# WILLOWTREE PLANNING

REF: WTJ21 - 285

**RE: RESPONSE TO SUBMISSIONS - PROPOSED SECTION 4.55(1A) MODIFICATION APPLICATION - SSD 9522 (MOD 2)**

**PROPERTY AT 657-769 MAMRE ROAD, KEMPS CREEK LOT 34 DP1118173, LOTS X & Y DP421633, LOT 1 DP 1018318 & LOT 22 DP258414)**

DRAWING TITLE
STATE SIGNIFICANT DEVELOPMENT APPLICATION PLAN

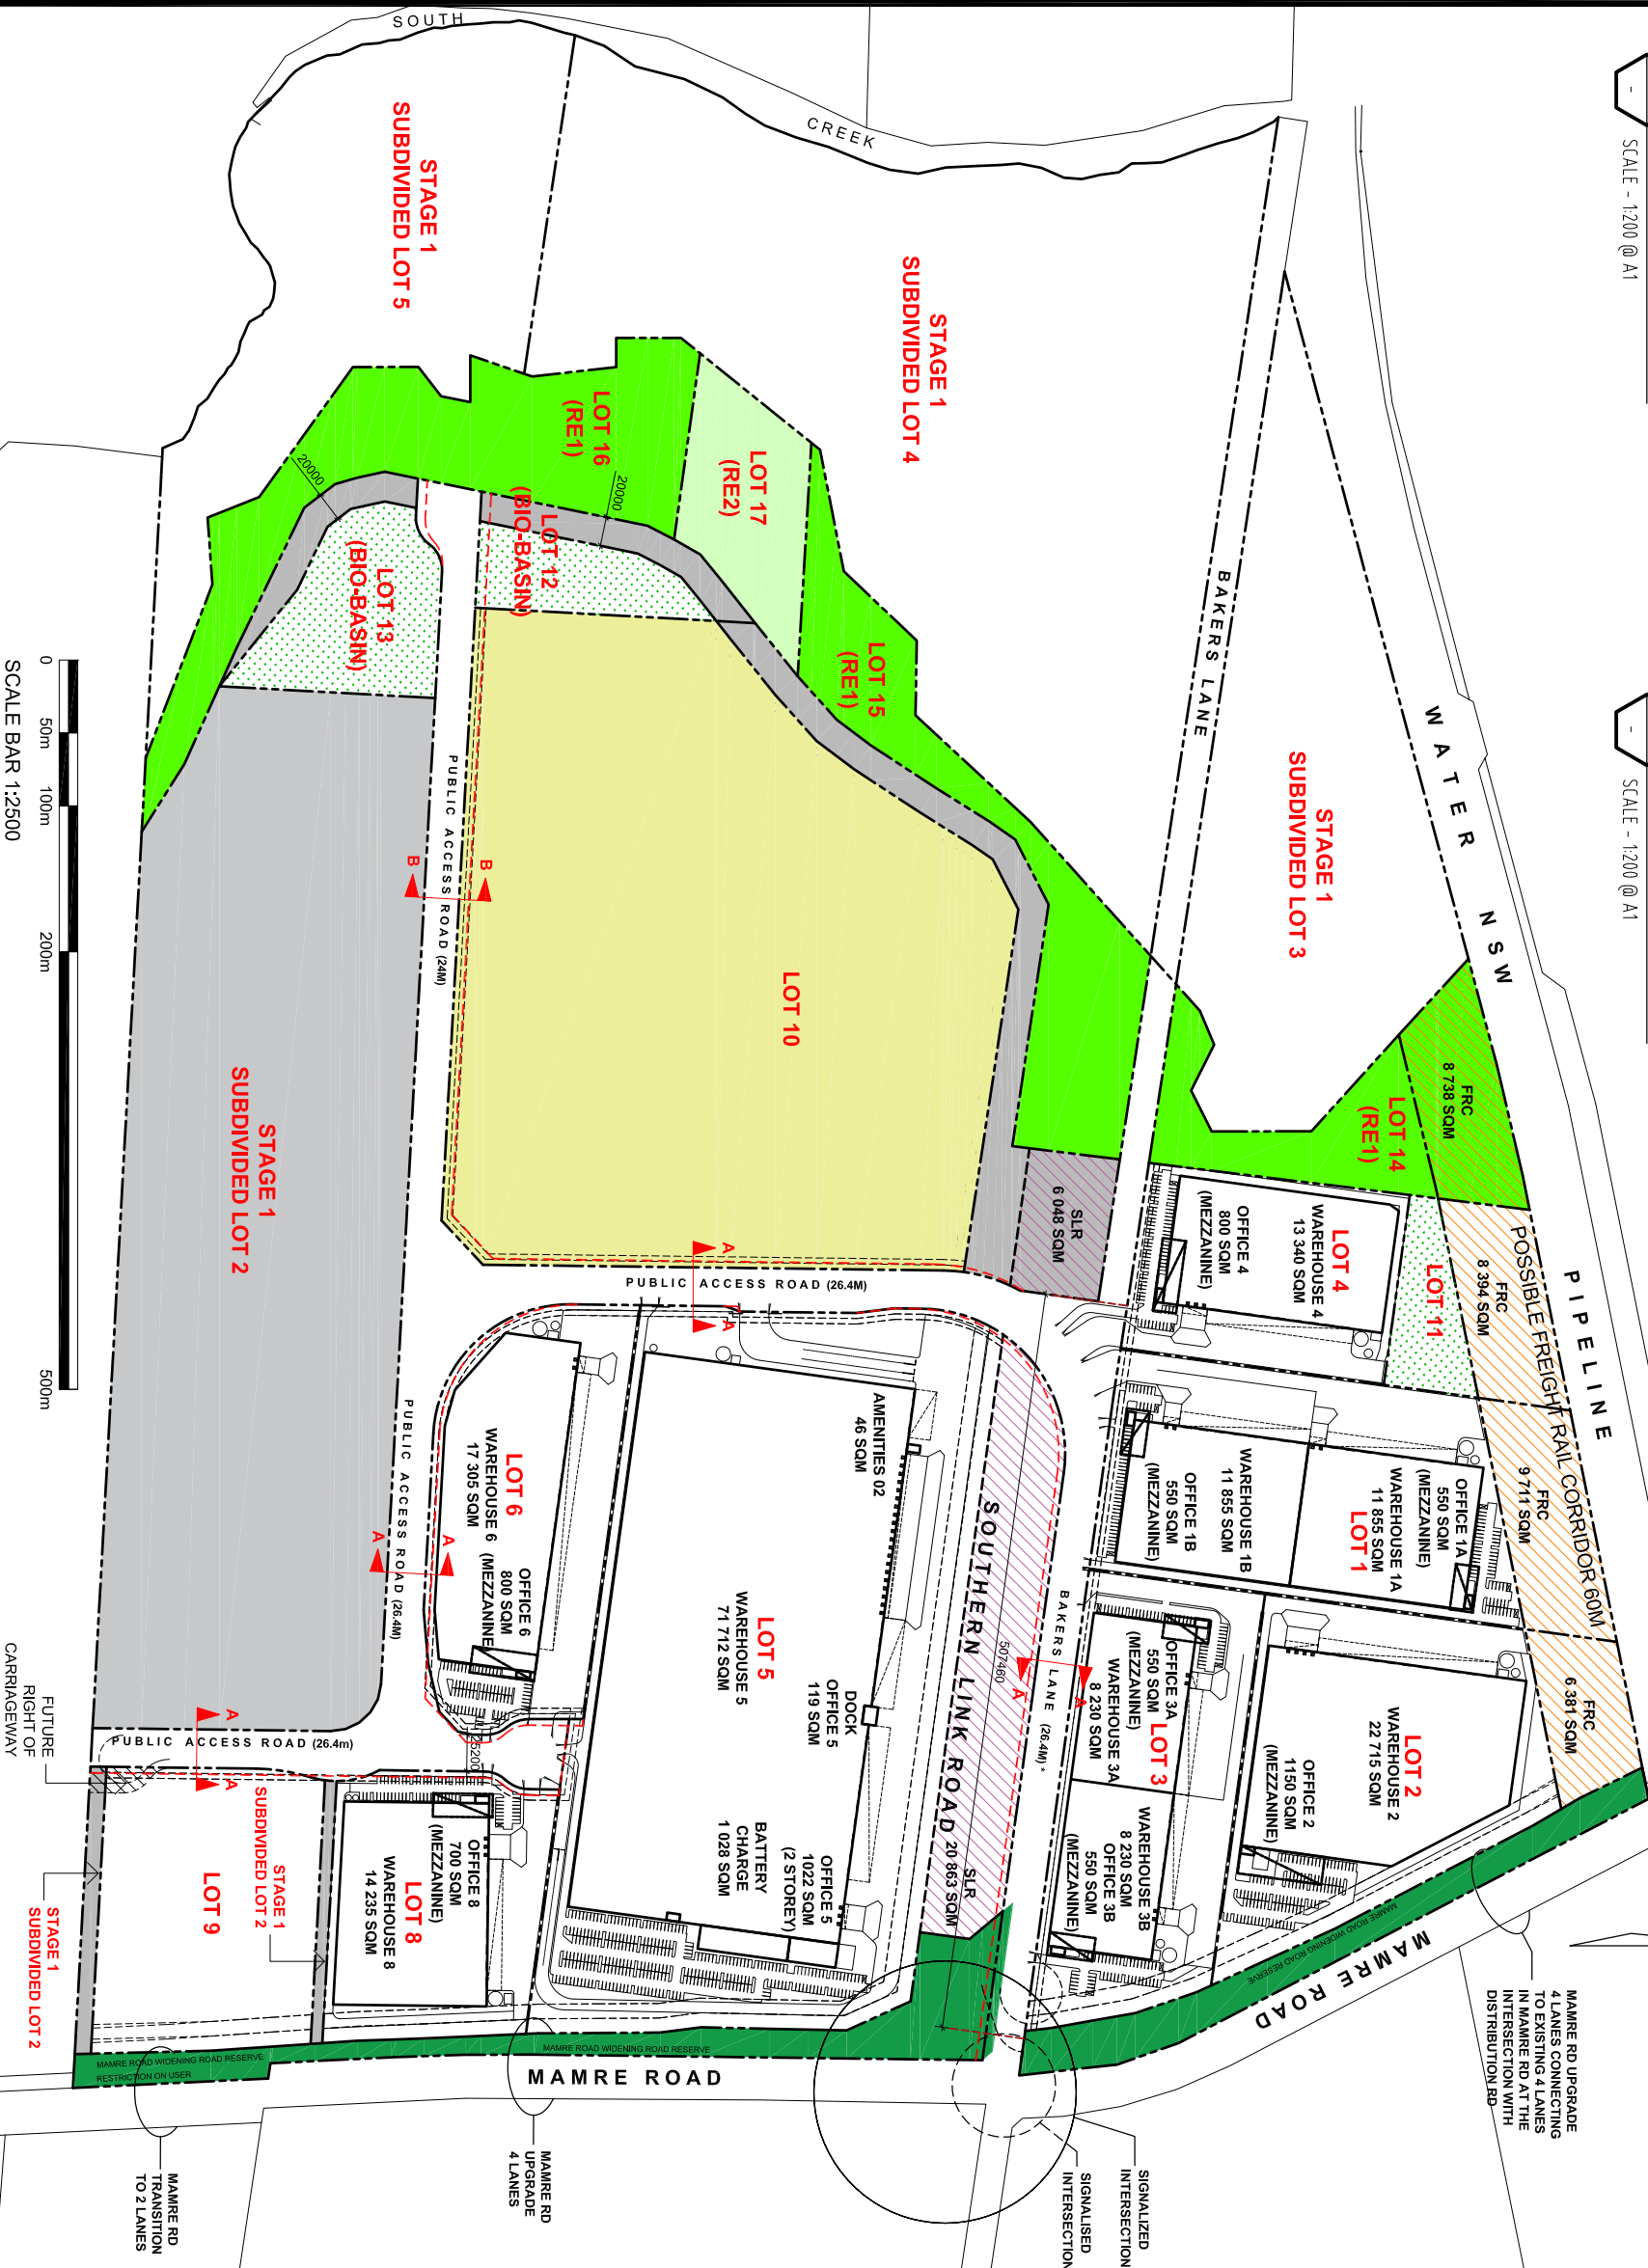
<p>(f) <u>Addition of car parking spaces</u></p> <p>Council does not support the proposed addition of five car spaces within the entry driveway to Lot 6.</p> <p>Council does not support any encroachments into the already reduced (4m to 3.75m under MOD 1) landscaped setback to Estate Roads.</p>	<p>The proposed additional parking is consistent with the Mamre Road Precinct DCP and site-specific DCP car parking requirements, as well as AS2890.1 and will not result in any additional traffic or parking impacts, as described in the submitted Traffic Report.</p> <p>Where appropriate, landscaped setbacks in excess of the requirements have been provided to compensate for any minor carpark intrusion into the landscape setbacks required by road curves. The overall quantum of landscaping is increased.</p>
<p>(g) <u>Landscaped blisters</u></p> <p>Landscaping must be provided in accordance with the requirements of the Mamre Road Precinct DCP. It is requested that landscaped setbacks be increased to comply with the MRP DCP.</p> <p><i>As per the requirements of the MRP DCP, tree planting in the form of island planter beds shall be provided at a rate of one planter bed per 10 car spaces (preference is 1 every 6 spaces) within car parks to reduce the heat island effect of hard surfaces that are a minimum 1.5m wide</i></p>	<p>The approved development is subject to the site-specific DCP and the controls contained in the Mamre Road Precinct DCP are not relevant to the subject modification application or approved development.</p> <p>The approved development is subject to the site-specific DCP and the controls contained in the Mamre Road Precinct DCP are not relevant to the subject modification application or approved development.</p>

Central Western Team Comments	
Road widths and design proposed by SSD-9522 Mod 2 must comply with the Mamre Road Precinct Development Control Plan 2021.	The road widths as proposed maintain compliance with the Mamre Road Precinct DCP
The proposed revised road widths should ensure that the buildings within the development comply with the landscaped setbacks established within the Mamre Road Precinct DCP 2021.	The development as modified will continue to provide areas for landscaping which are generally consistent with the approved development and site-specific DCP. Where appropriate, landscaped setbacks in excess of the requirements have been

<b>Summary of, and response to comments</b>	
<b>Comments</b>	<b>Response</b>
	provided to compensate for any minor carpark intrusion into the landscape setbacks required by road curves. The overall quantum of landscaping is increased.
DPIE's Chief Engineer should be consulted with respect to road safety and the design of the north-south road.	The complete road design has been provided within the submission of the modification application for review by DPIE's Chief Engineer if required.
